From: Paul Cann
Sent: 15 May 2017 12:17
To: Planning.Responses
Subject: RE: Planning Consultation on Y/13/17/DOC

APPLICATION **Y/13/17/DOC**
NO:

Registered: 14-MAR-17
Site Address: 38 Cherry Avenue Yapton BN18 0LB

Description of Application for approval of matters reserved by condition
Works: imposed under Y/57/16/HH relating to condition 3 for surface
water drainage scheme.

Schematic Diagram for Section 1074-1

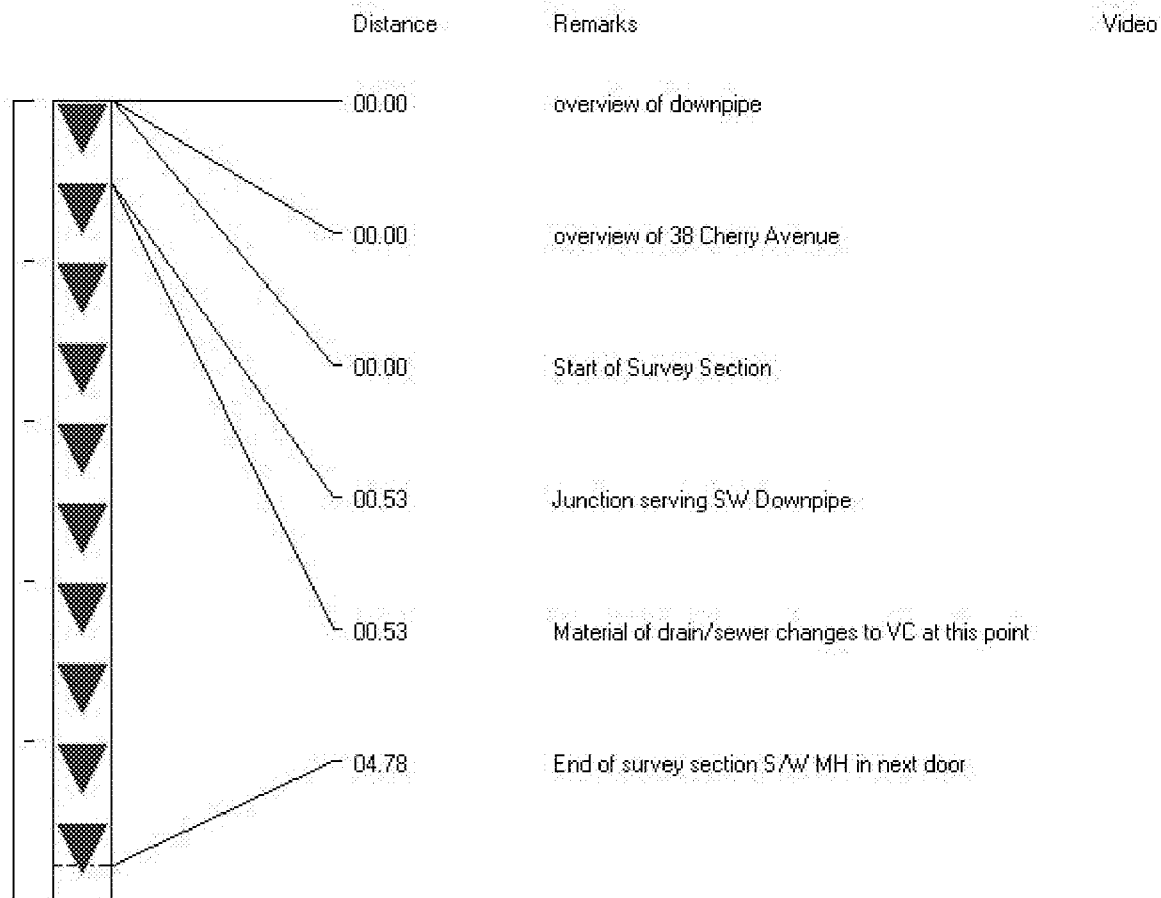
Having reviewed the CCTV survey, it is apparent that the existing pipe appears in good condition but is only 100mm diameter. On that basis, the connection from the new extension is acceptable provided that a new manhole (construction details required) is constructed where the new rainwater pipe will connect to the existing pipe.

GROUND FLOOR LAYOUT

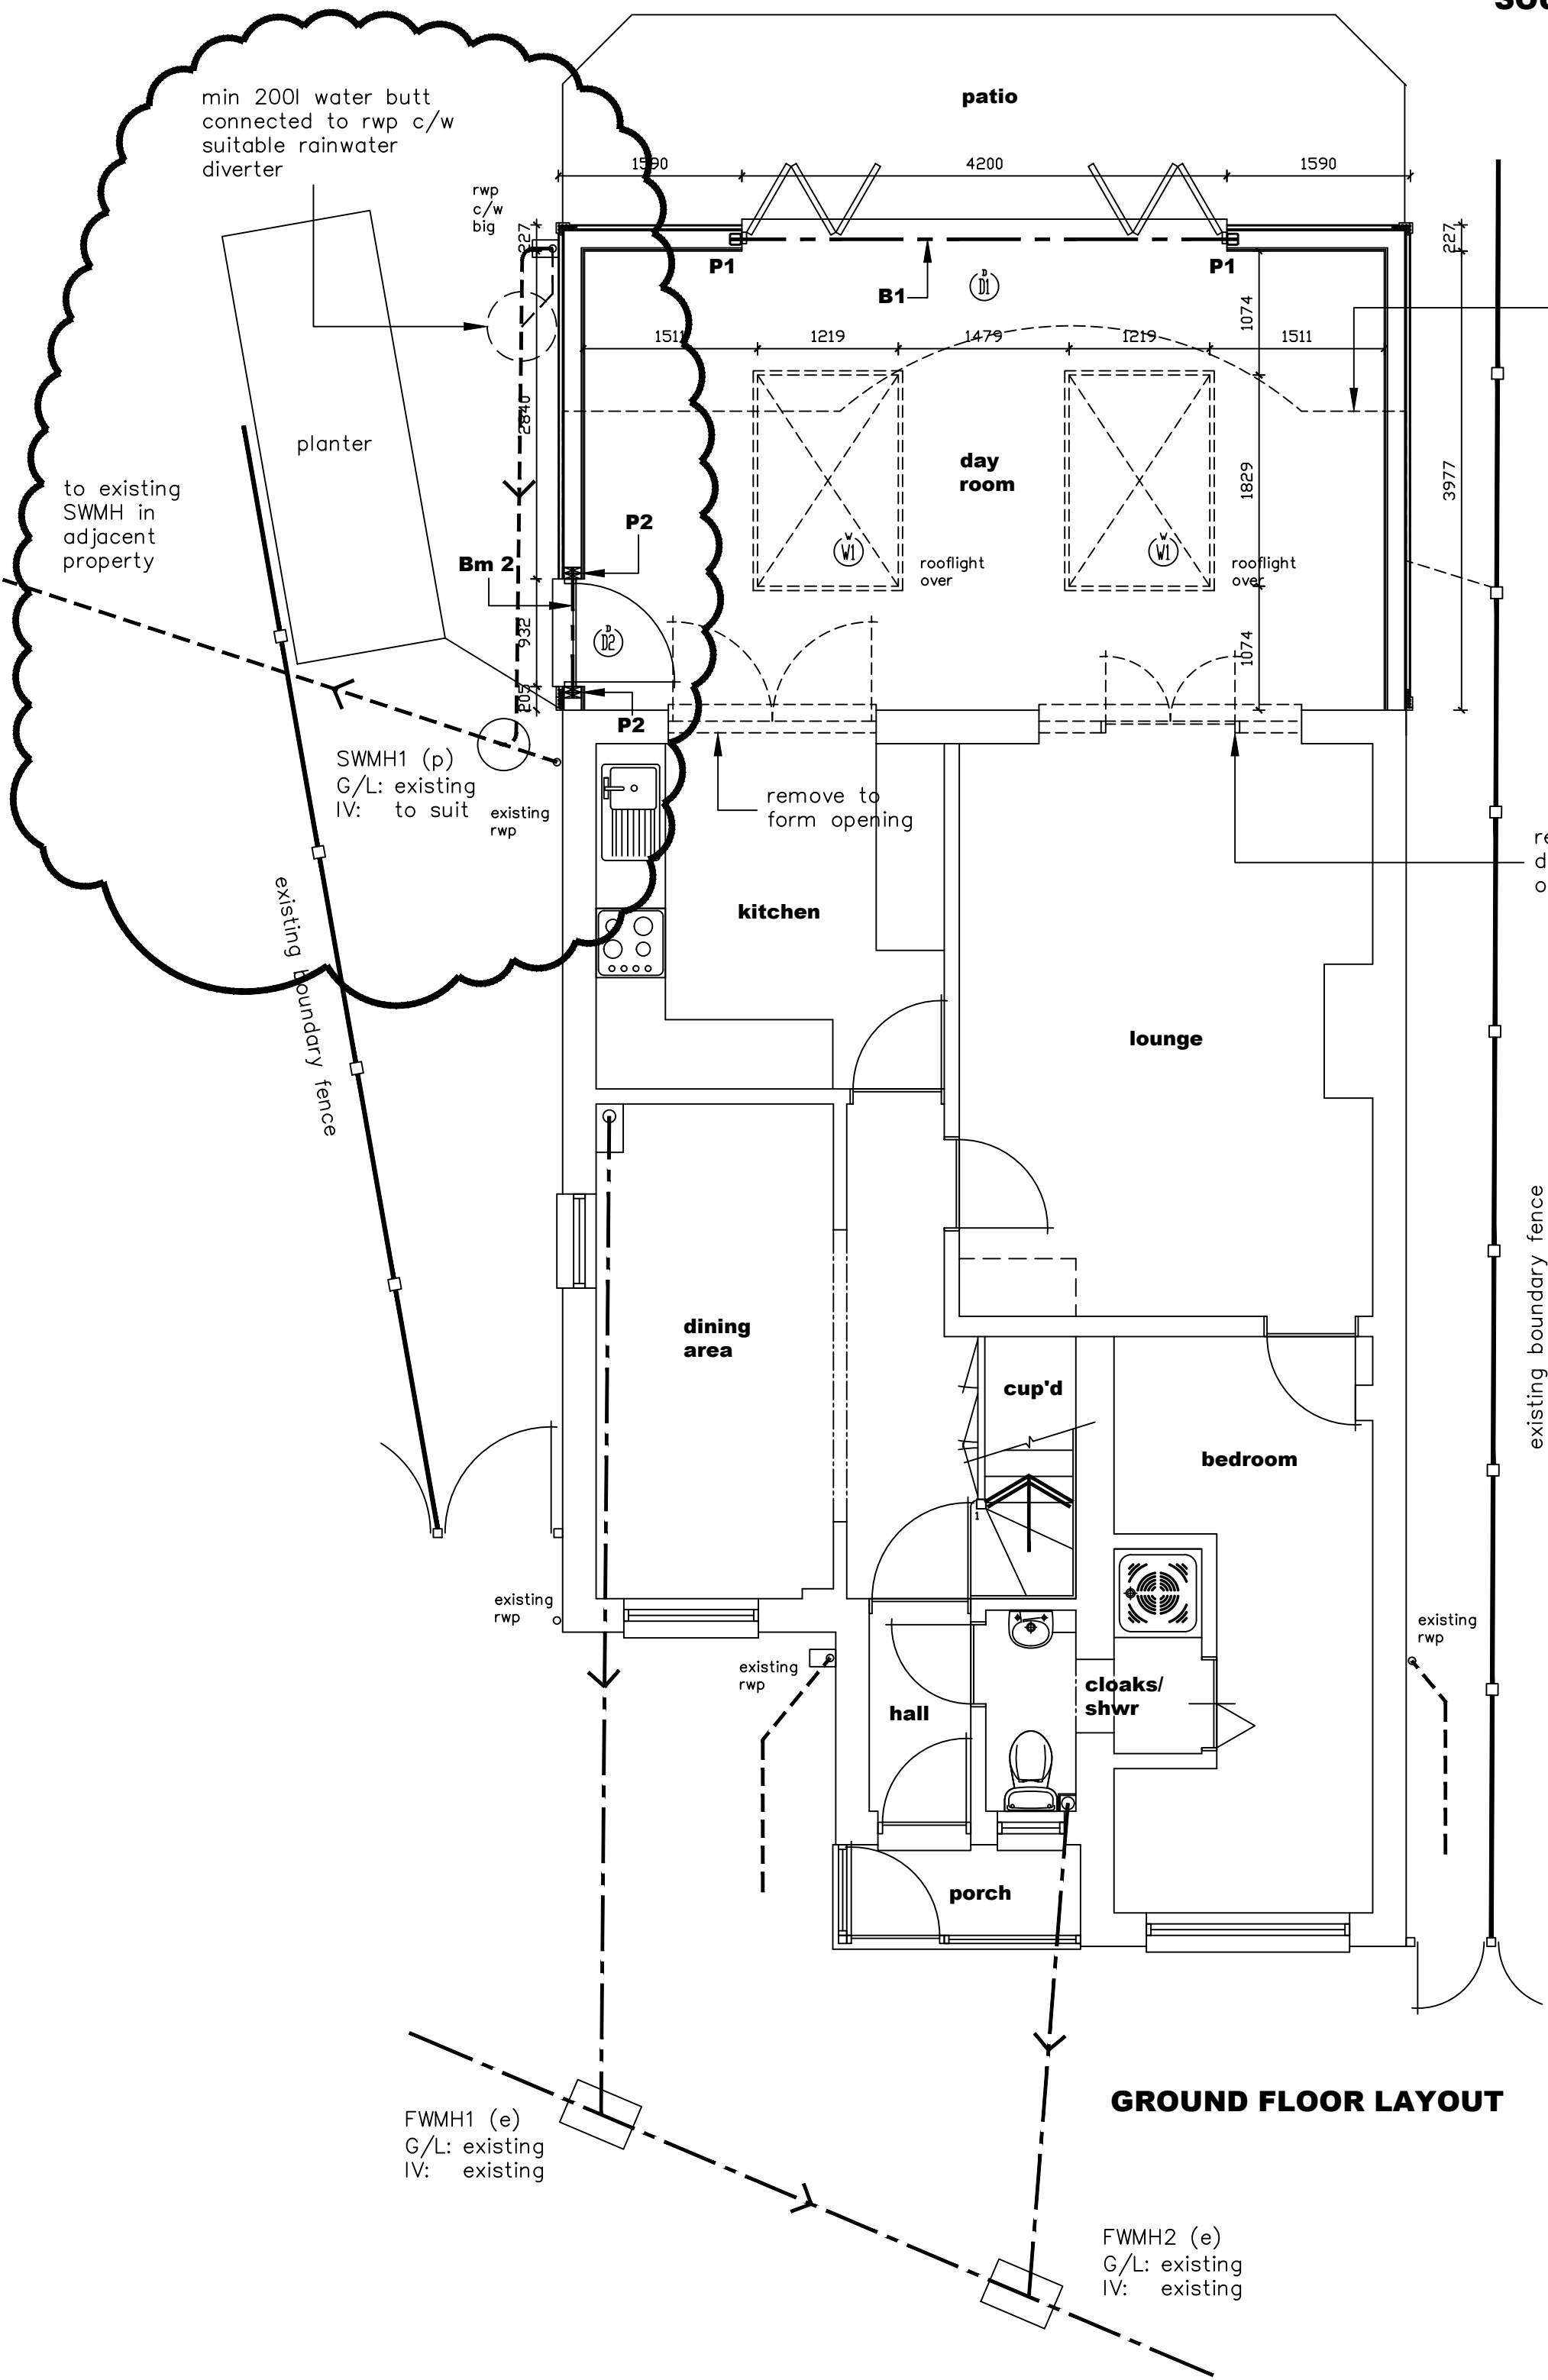
Also, a minimum 200 litre water butt is to be connected to the new rainwater downpipe via a water diverter/overflow. See enclosed picture of the diverter/overflow arrangement. The water butt will help store water at times when the water butt is empty/partially empty, and when full will overflow back into the piped system.

Please could the applicant provided a revised plan indicating these requirements, so that it can be considered further.
